C1967 The Grange, Westergate (Designer reply in red)

Engineers Comments Regarding Surface Water Drainage - Condition 10

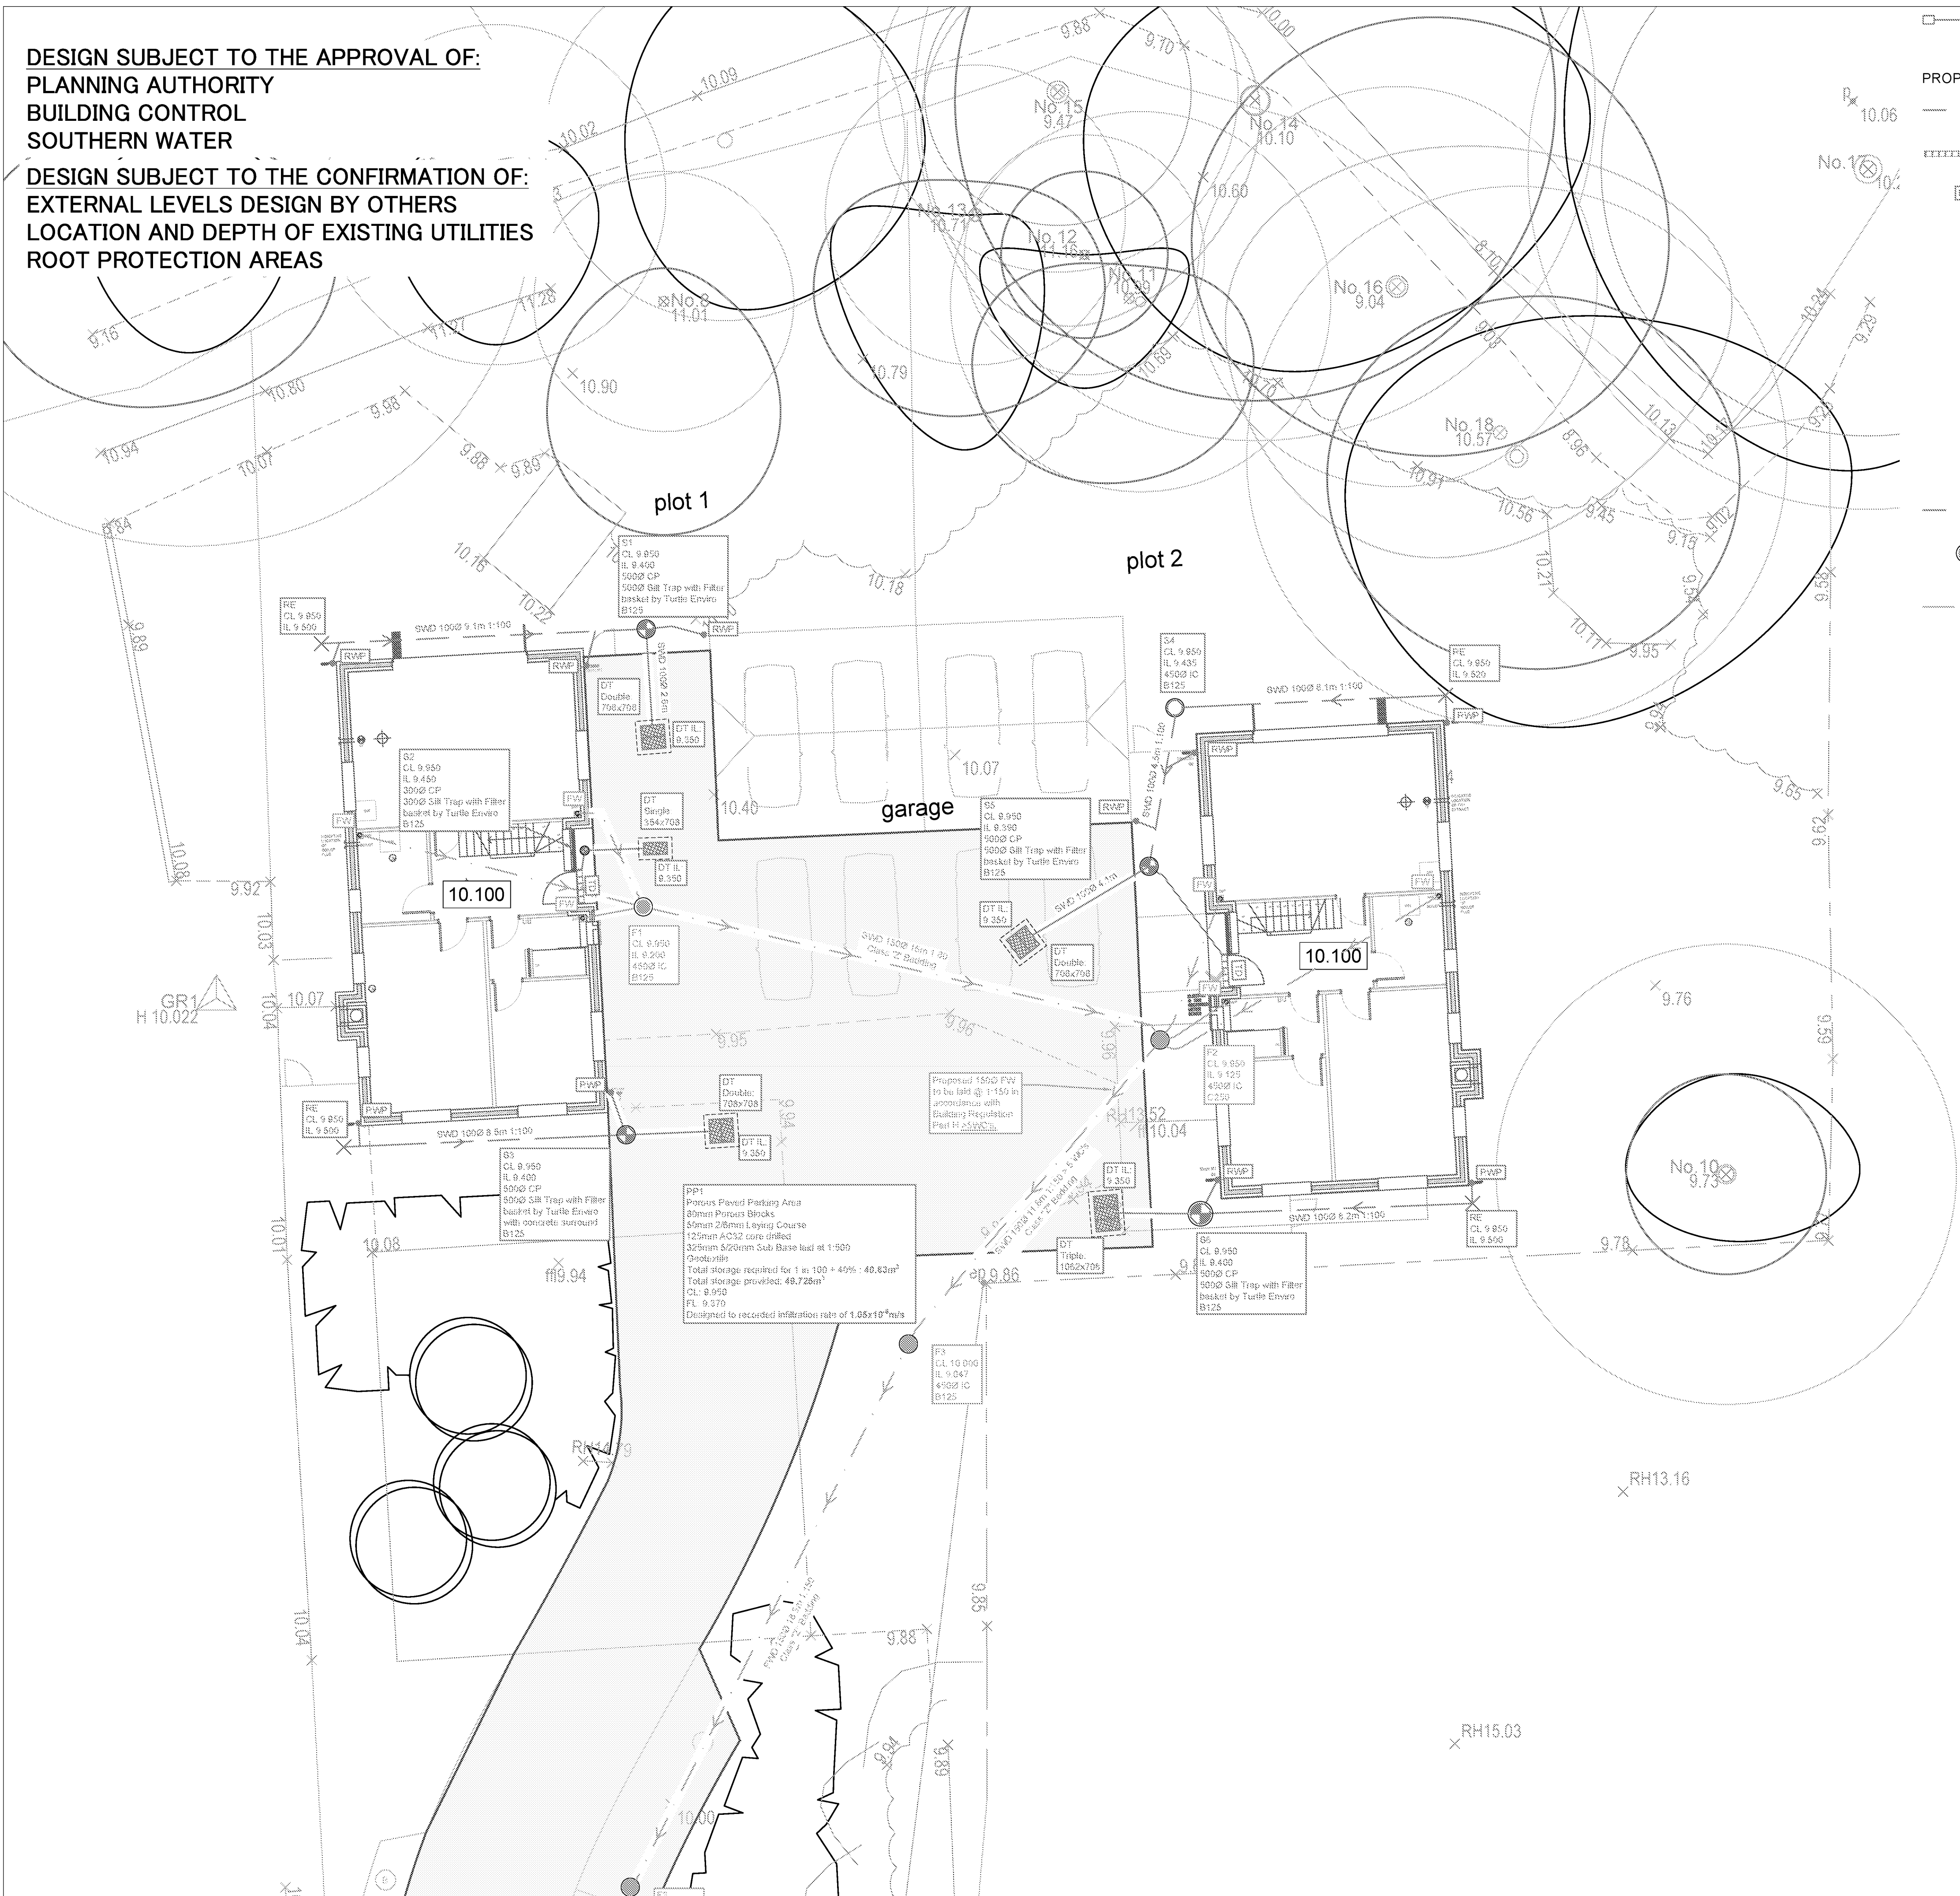
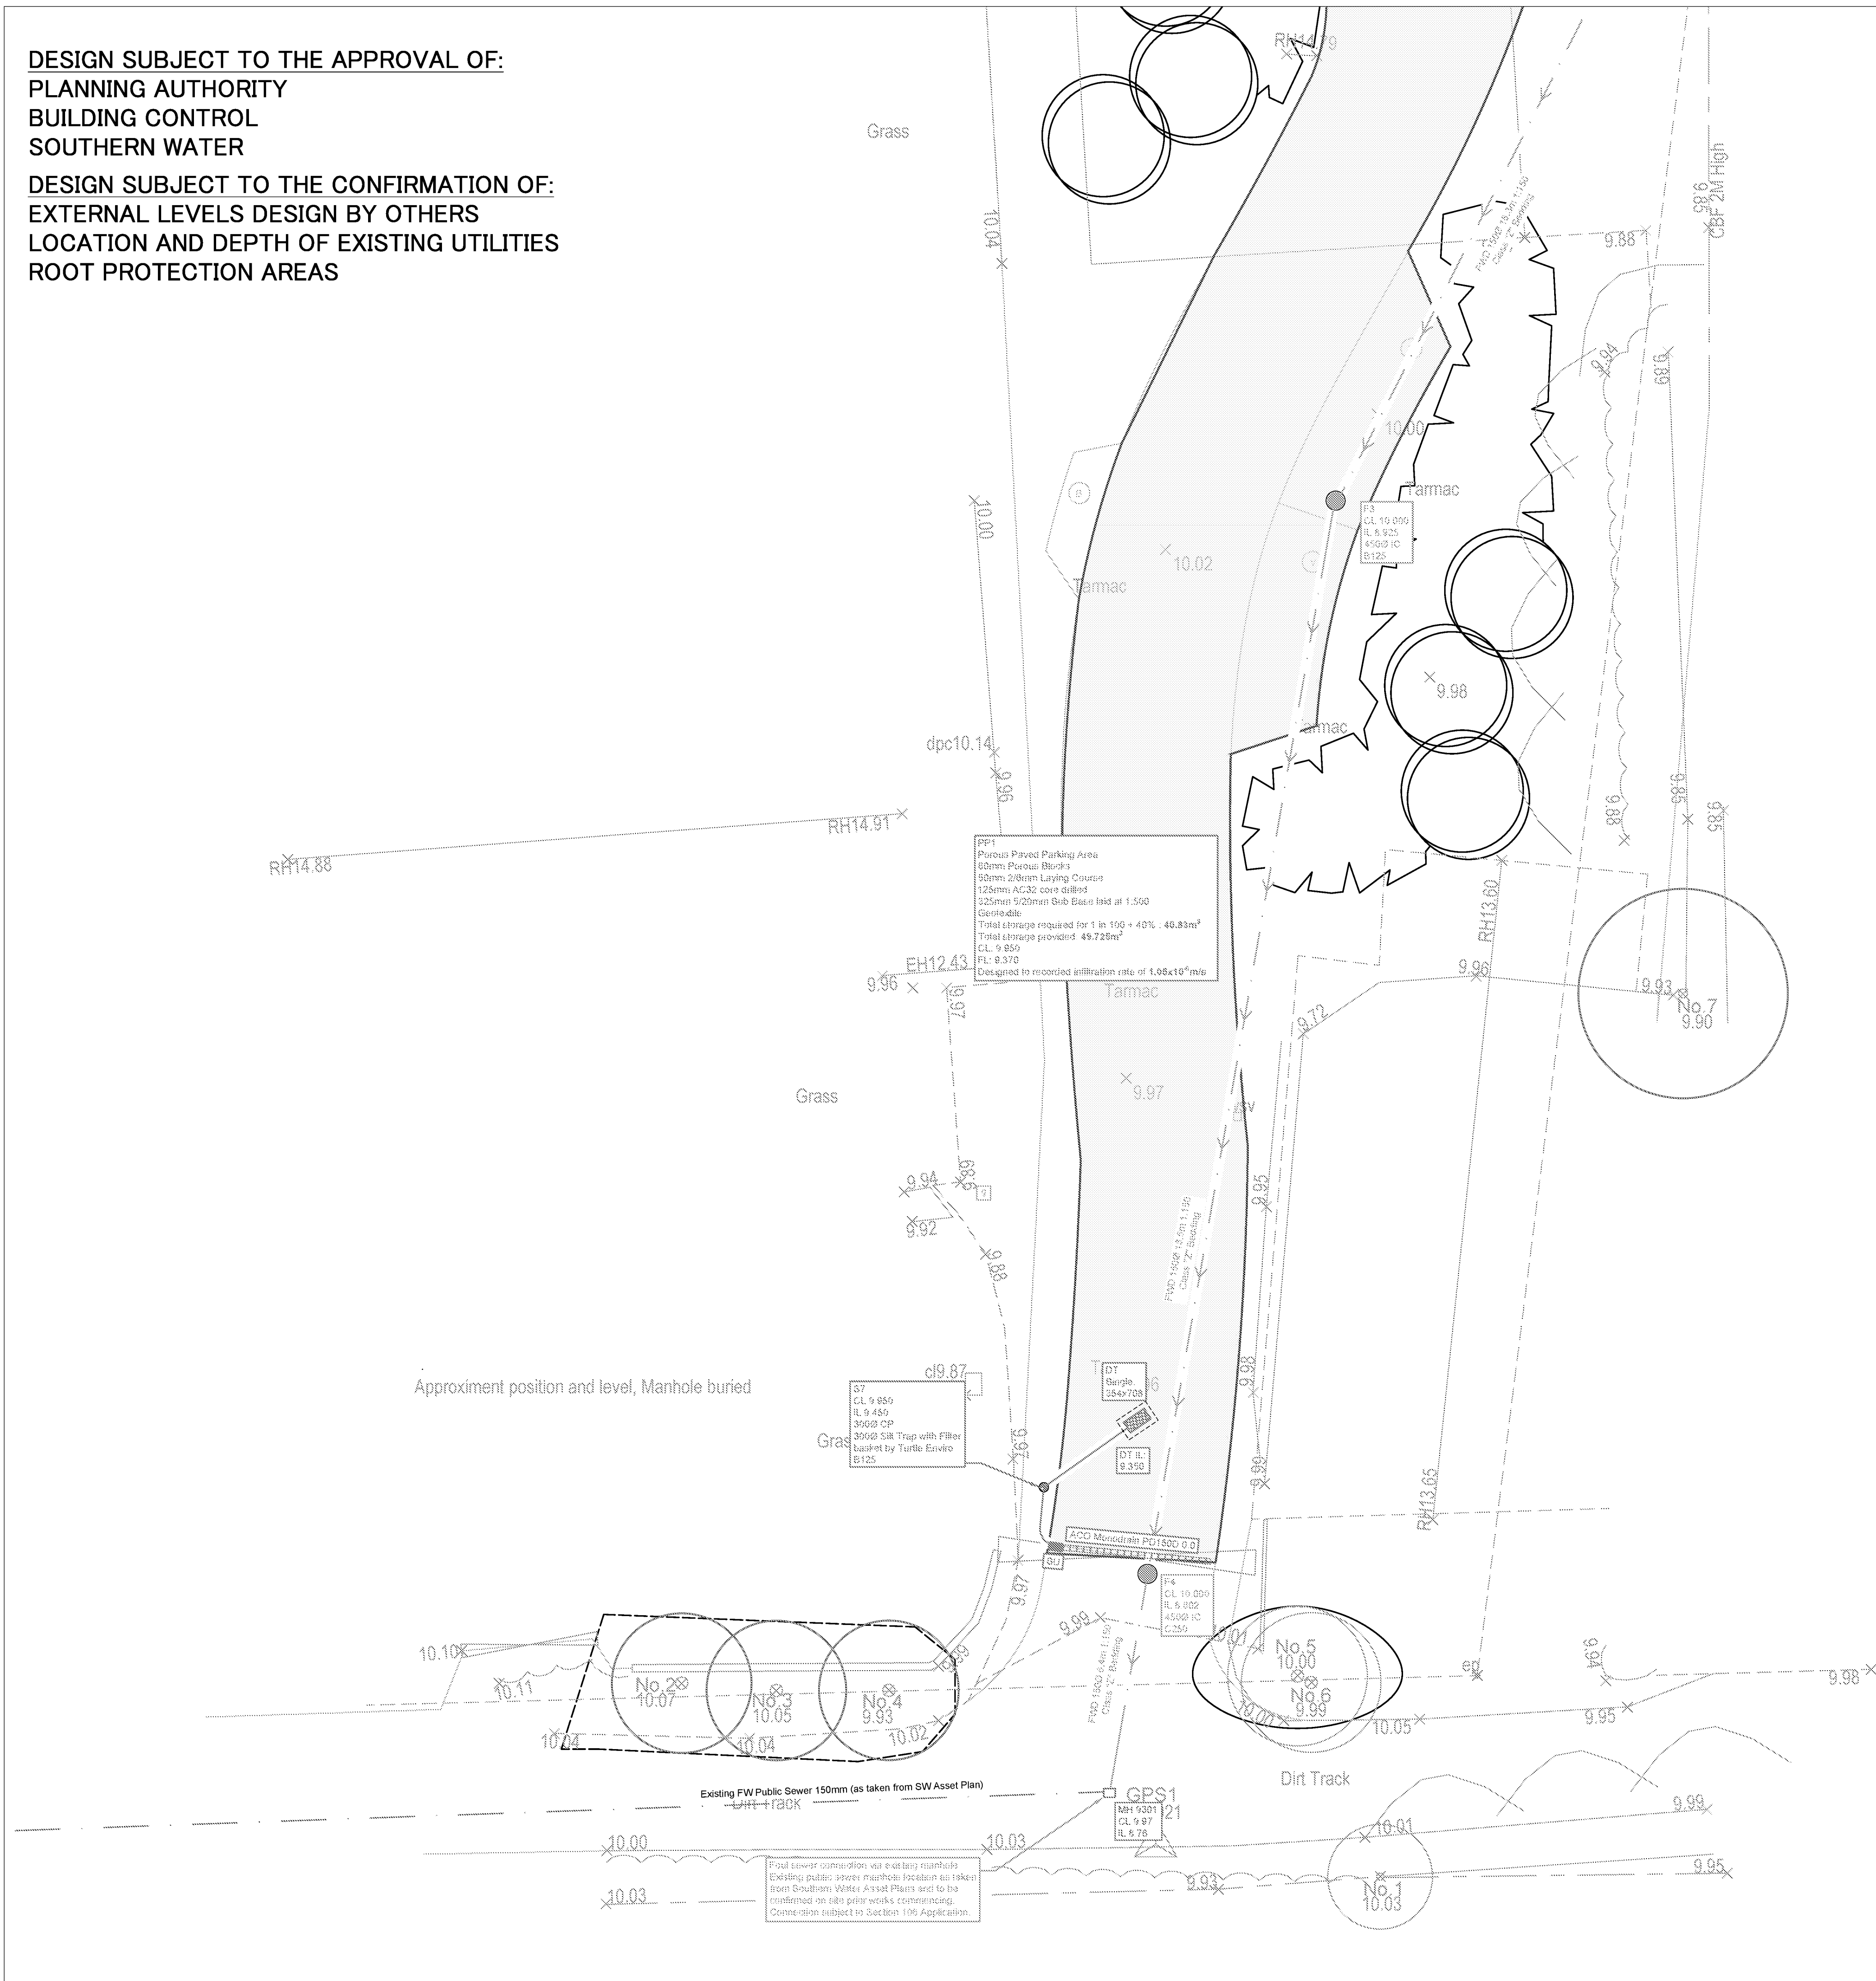
2. Please include a scale bar on the drainage layout so impermeable areas and diffuser distances from structures can be checked. Alternatively please show measurements for the same purpose.

- h. The permeable paving invert level is set to 0.380, yet formation level is shown as 9.370 on the drainage layout. The value of 9.370 corresponds with the formation shown in the construction details, therefore please correct the calculations to reflect this.

- i. Slope is listed as 1:800 but on the drainage layout it is stated that sub base is laid at 1:500. Please correct.

4. Drainage layout

- a. Please include pipe gradients.
- b. Diffuser blocks should be set above the 1 in 10 year +40% critical storm event. They are currently set below the formation level of the permeable paving (diffuser inverts at 9.350 – permeable paving formation at 9.370). These should also be located a minimum of 5m from all controlled structures, see point 3. Please correct.

- c. It is not clear why there are apparently random dotted lines on the drainage layout, please can their use be clarified or they be removed.

- d. Please detail sump depths for catchpits.
5. Please amend Typical distribution Tank Outflow Detail to show all diffuser blocks above the 1 in 10 year + 40% critical event as per point 5b.

Please find updated drawing attached

The proposed voided subbase has been updated and is now 375mm thick so the permeable paving subbase IL is now set as: 9.320

Please find the updated drainage calculations attached. It is proposed that voided subbase is now laid flat.

The proposed diffuser block has been relocated minimum 5m away from the proposed structures. The proposed diffuser tanks act as an outlet (discharge) connection into the subbase formation. We do understand that incoming pipe IL should be set above the 1 in 10 year + 40% CC level for the traditional soakaway system, however the proposed surface water runoff will be discharged into the voided subbase and therefore to achieve this, the proposed subbase IL will need to be dropped by approx. 300mm. This will make the proposed subbase 600mm deep and due to the associated costs not viable. We could propose using a traditional soakaway system however, noting the groundwater levels surface water runoff will therefore need to be attenuated and discharged into the onsite foul drainage system. By doing this, there is a risk of the proposed SW discharge into foul drainage network being refused by statutory undertaker.

The proposed drainage system has been designed so the surface water level for the 1 in 10 years + 40% is below the proposed access points (rodding eye) ILs.

Furthermore, the proposed FFL has been set at min. 300mm above the top of the proposed voided subbase and the maximum surface water level for the 1 in 100-year rainfall event + 40%CC + 10% UC.

The dotted lines on the drainage layout around the diffuser tanks are indicated on drainage legend.
